**Consultation Response from KC,
Highways Development Management**

2024/90918 Land off Grange Road, Soothill, Batley

Formation of hardstanding area and change of use of land to storage area siting 78 shipping containers

Date Responded: 18th July 2024

Project Proposed storage facility at Grange Road, Soothill, Batley
 Client MB Storage, Greenhill Mills, Grange Road, Soothill, Batley WF17 6LH
 Dwg Title (23259)2 Layout Plan
 Scale 1: 200 @ A1
 Date Mar 24

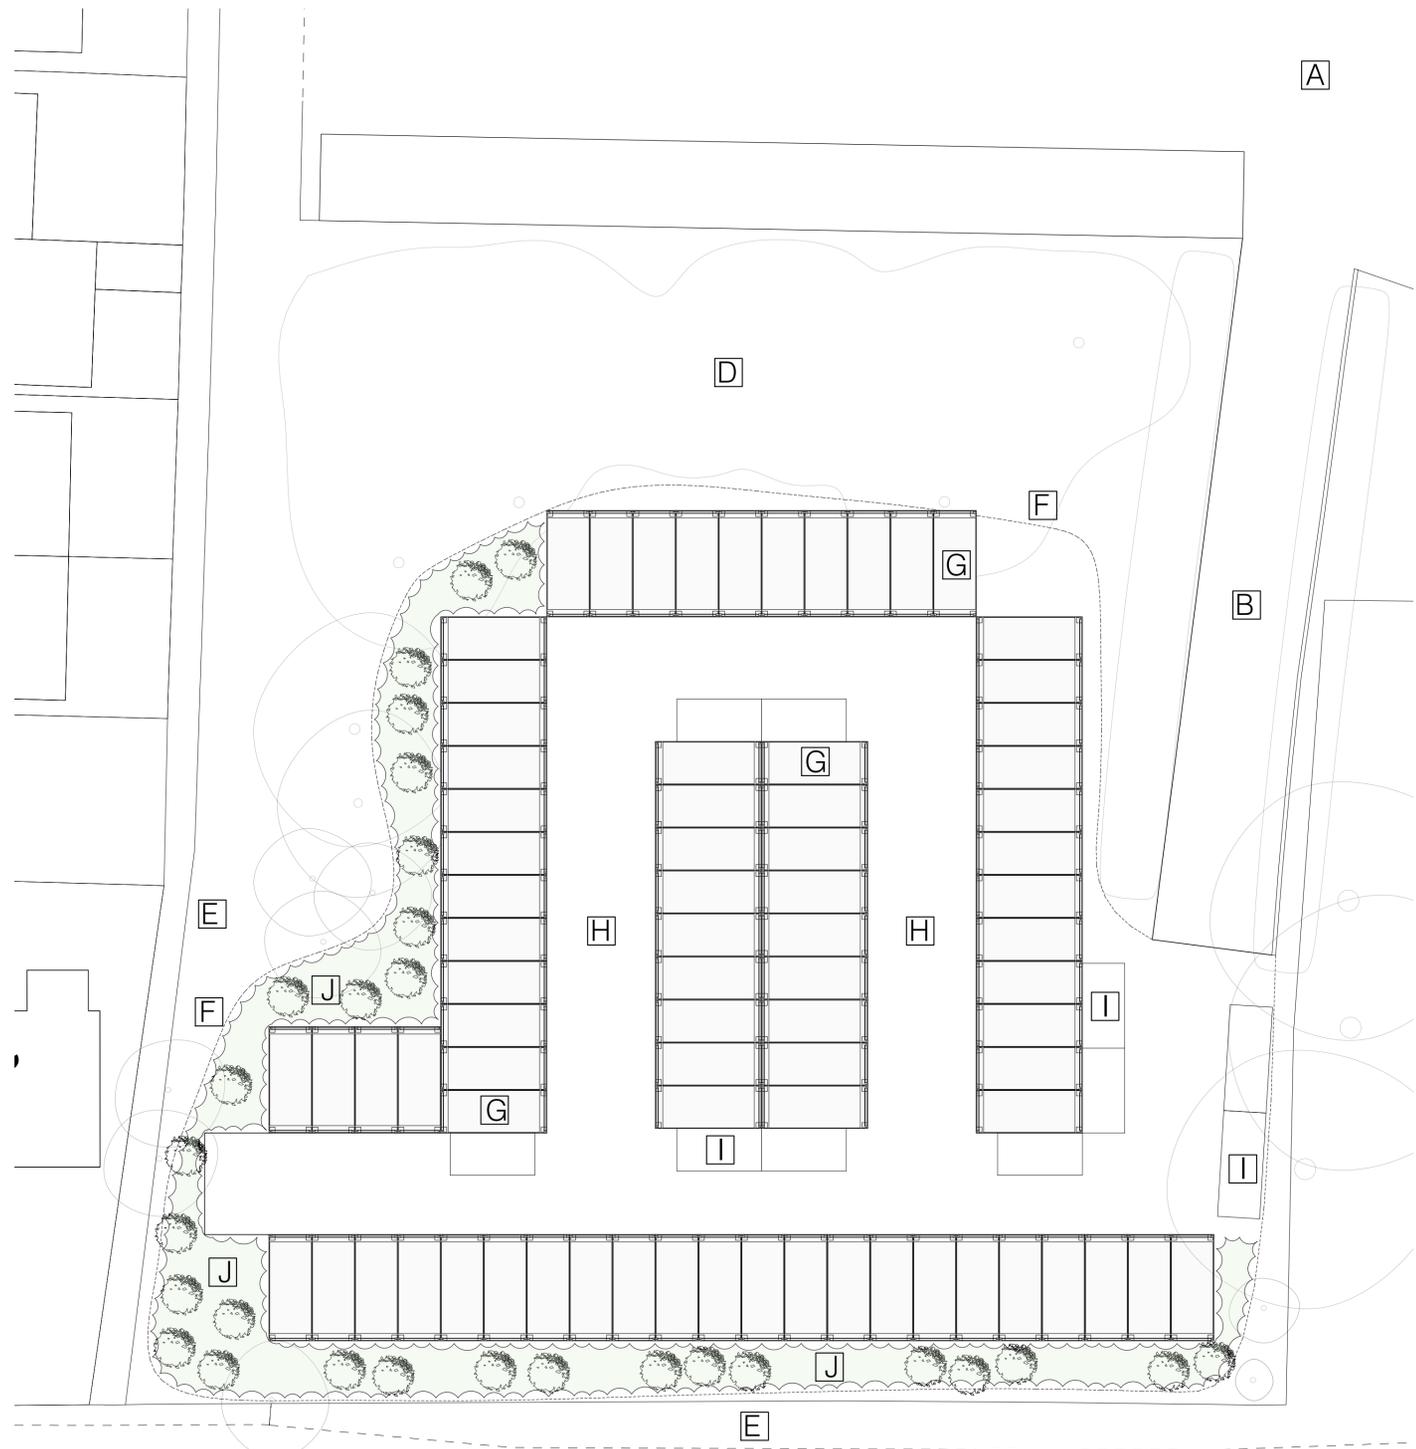
The site is accessed from Grange Road via the existing access, which is considered suitable for the scale of development proposed, utilising the existing internal access roads through the wider industrial site to access the application site. Delineation of the internal access route through the site is not ideal and a condition is proposed requiring submission and installation of a detailed signing scheme directing customers to and from the site.

The containers are laid out to provide a circulating access route, which minimises reversing manoeuvres, with 10 customer parking spaces, which is considered adequate for a development of this scale.

Access Route Signage

Development shall not be occupied until details (including location and size) of proposed Access Route signage, clearly visible to motorists, have been submitted to and approved in writing by the Local Planning Authority. The approved works shall be completed before the development is occupied and retained for the lifetime of the development.
